CITY OF ALBUQUERQUE

Re: RGCU Marble
1201 San Pedro Dr. NE
Traffic Circulation Layout
Engineer's Stamp 05-22-20 (J18-D008)

CS101  
OF

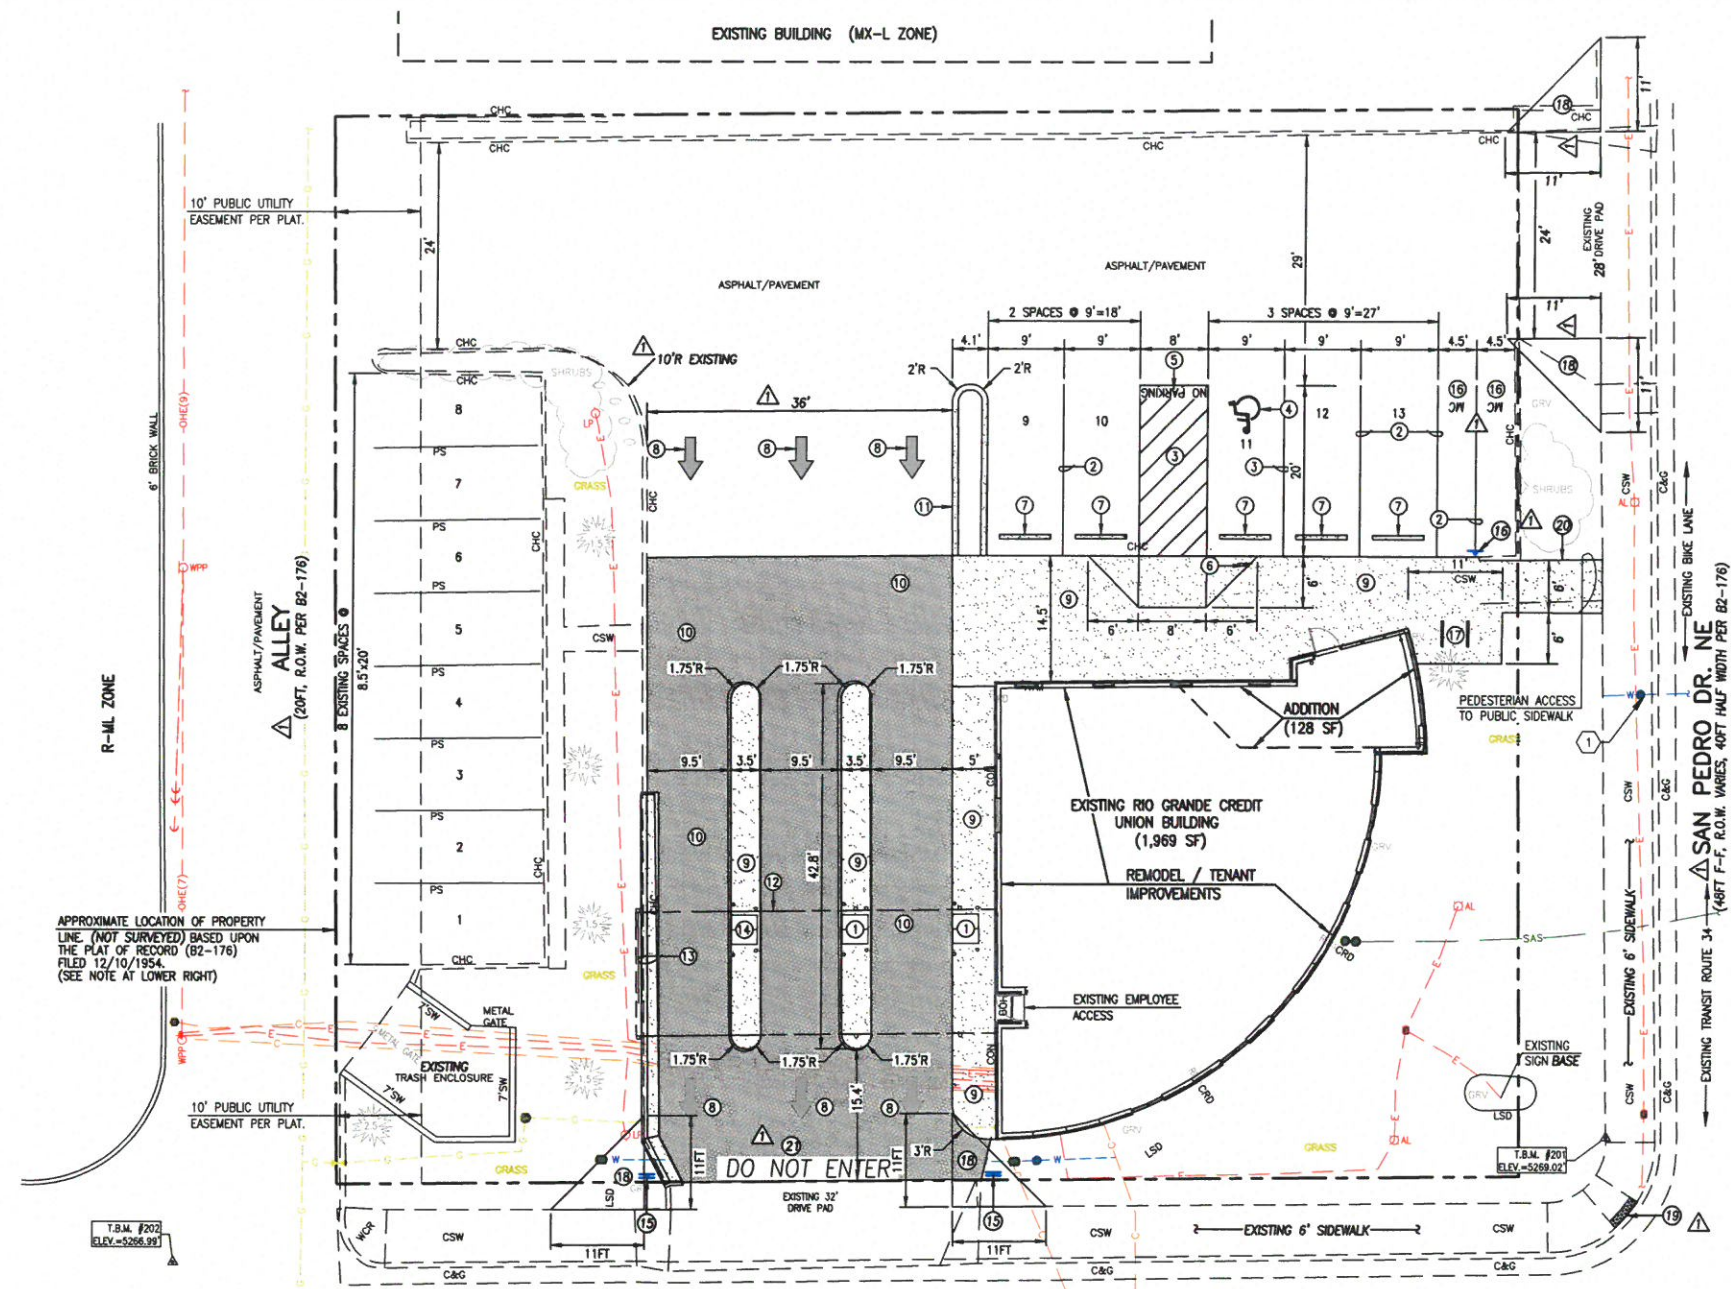
1. Please coordinate and verify all calculations for parking spaces, including bicycle and motor cycle parking with Zoning and list the number required.

2. Identify the right of way width, medians, curb cuts, and street widths on the existing alley way, Marble Ave and San Pedro.
3. Clarify existing property line location and configuration, you have two dashed lines.

4. Please list the width and length for all existing and proposed parking spaces. Some dimensions are not shown.
5. All ADA curb ramps, within public, must be updated to current standards and have truncated domes installed. At the corner of Marble and San Pedro that appears to be no existing ADA wheel ramp, please address these concerns.

6. Motorcycle parking spaces shall be designated by its own conspicuously posted upright sign, either free-standing or wall mounted per the zoning code. Label pavement MC (Adjust keyed note 16 to reflect these requirements).

7. All bicycle racks shall be designed according to the following guidelines:
 - a. The rack shall be a minimum 30 inches tall and 18 inches wide.
 - b. The bicycle frame shall be supported horizontally at two or more places. Comb/toaster racks are not allowed.

- f. Each bicycle parking space is accessible without moving another bicycle.
- 8. Bicycle racks shall be sturdy and anchored to a concrete pad.
- 9. A 1-foot clear zone around the bicycle parking stall shall be provided.

- 10. Bicycle parking spaces shall be at least 6 feet long and 2 feet wide.
- 11. Show all drive aisle widths and radii (proposed and existing). Some dimensions are not shown.

- 12. List radii for all curves shown; for passenger vehicles. Radius for delivery trucks, fire trucks, etc. is 25 ft. or larger(Explain if this is applicable, Fire dept approval is needed).

- 13. Per the IDO, a 6 ft. wide ADA accessible pedestrian pathway is required from the public sidewalk to the building entrances. Please clearly show this pathway and provide details (verify existing complies with requirements).

- 14. All sidewalks along streets: Provide existing widths.
- 15. Parking areas shall have barriers to prevent vehicles from extending sidewalk (existing parking stall adjacent to alley way).

- 16. Refuse vehicle maneuvering shall be contained on-site. The refuse vehicle shall not back into the public right of way.; provide a copy of refuse approval.

- 17. All one-way drives shall have "One Way" and "Do Not Enter" signage and pavement markings. Please show detail and location of posted signs and striping.

- 19. Please provide a sight distance exhibit (San Pedro entrance).
- 20. Show the clear sight triangle and add the following note to the plan:
"Landscaping and signage will not interfere with clear sight requirements. Therefore, signs, walls, trees, and shrubbery between 3 and 8 feet tall (as measured from the gutter pan) will not be acceptable in the clear sight triangle.

- 21. Please specify the City Standard Drawing Number when applicable.
- 22. Shared Site acces: driveways that straddle property lines, or are entirely on one propertybut are to be used by another property, shall have an access easement. Please include a copy of your shared access agreement with the adjacent property owner.

24. Work within the public right of way requires a work order with DRC approved plans.
25. Please add a note on the plan stating "All improvements located in the Right of Way must be included on the work order."
26. Add a note stating "All broken or cracked sidewalk must be replaced with sidewalk and curb & gutter." A build note must be provided referring to the appropriate City Standard drawing.
27. All keyed notes that reference details sheet: the reference sheets need to be provided (Sheet CS501).
